Address: 93 Marsh Lane Huddersfield HD8 8AP

Application number: 2024/93421	
What is the application for?:	Erection of first floor extension and associated alterations
Address of the site or building:	91, Marsh Lane, Shepley, Huddersfield, HD8 8AP
Postcode:	HD8 8AP

East Elevation
(side)

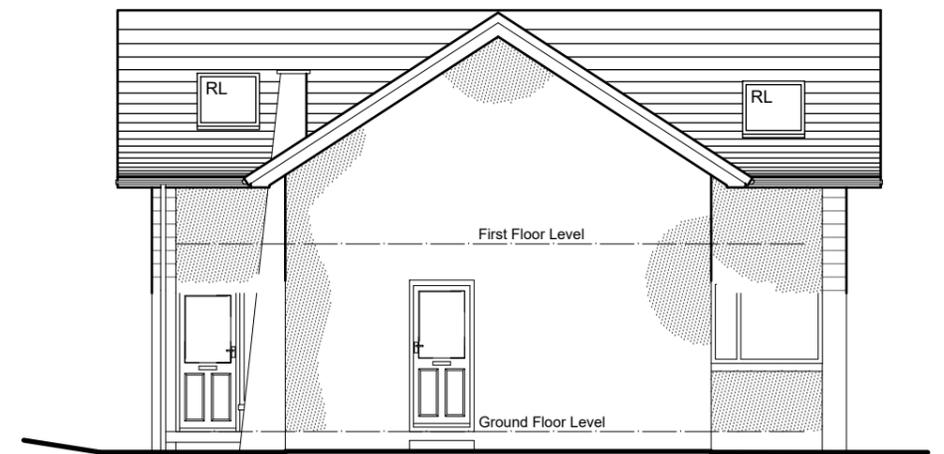
Type of comment: An objection	
Do you wish your comments to be published on the website anonymously?	No
I have privacy concerns about the two window lights on the West elevation overlooking my groundfloor bedroom. I feel they would be an invasion of the privacy I have enjoyed for over thirty years. Window lights are also shown on the North elevation so these two West facing windows do not appear to me to be essential.
